**Consultation Response from KC,  
Trees**

**2020/93867 adj, Red Lea, 27, Church Lane, Mirfield, WF14 9HX**

**Outline application for erection of residential development and formation of new access**

**Date Responded:24/03/21 | Responding Officer:JR | Responding Ref: TPO 18/89**

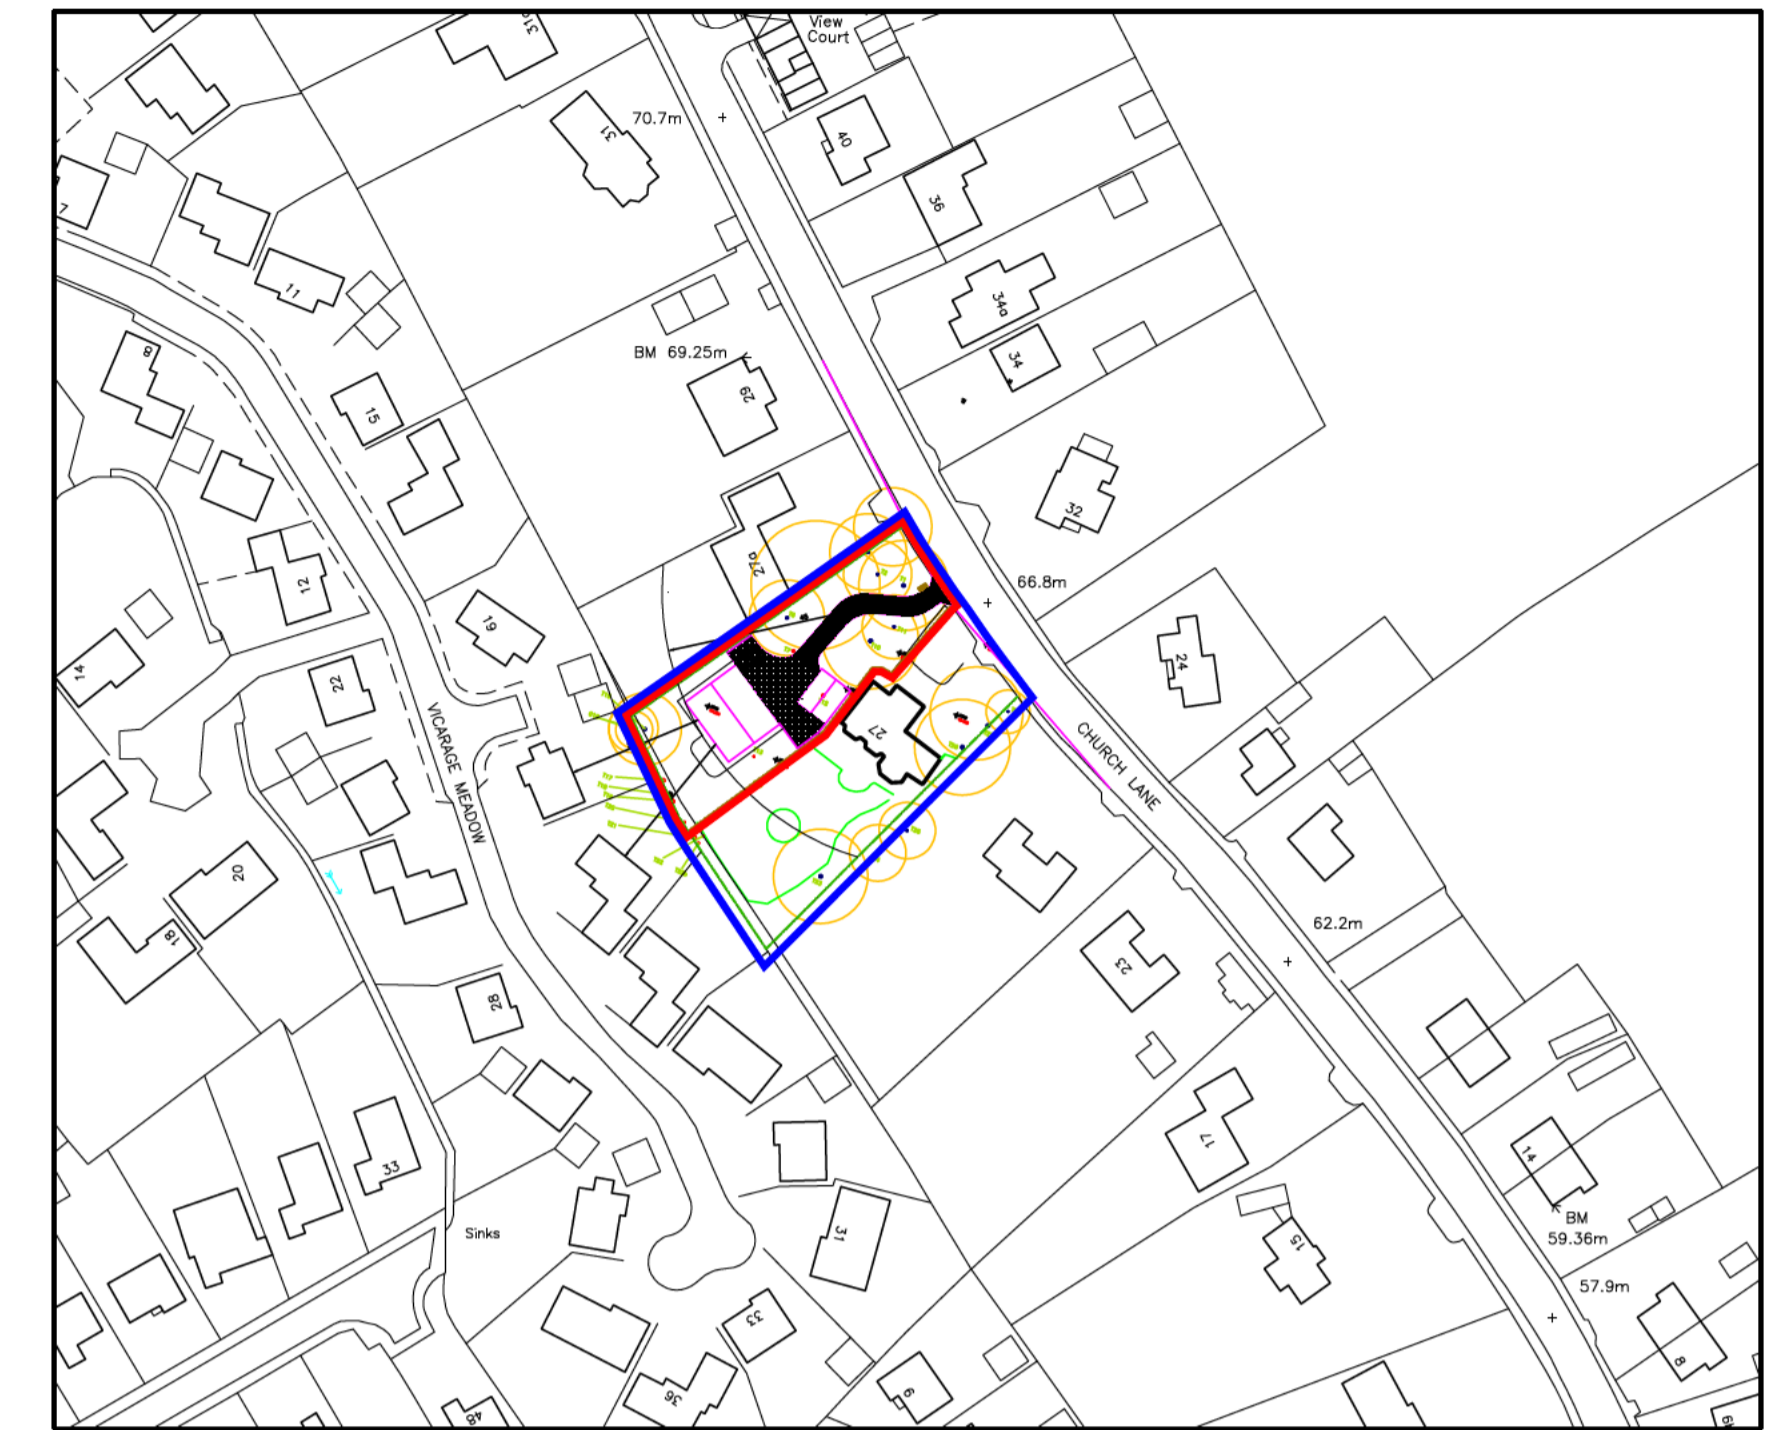
There is concern about the access drive way which is proposed, weaving between the protected trees. Insufficient information has been provided with the application to clearly demonstrate that this access can be constructed while avoiding impact on the protected trees.

Based on the current information it is difficult to see that a no dig system for the drive way is feasible. We would also expect to see technical details of the cellular confinement system which is proposed to be used. In addition, there is no information to show where all the utilities will be routed, are they intended to be down the driveway or through the tree group or will this be restricted. Is it possible to link to existing services while avoiding the trees.

Furthermore, given the tree and access constraints, how will construction access be facilitated. Is it anticipated that construction traffic deliveries etc will be using the proposed driveway, if so is there sufficient room to accommodate this and will the cellular confinement system be suitable for this type of traffic.
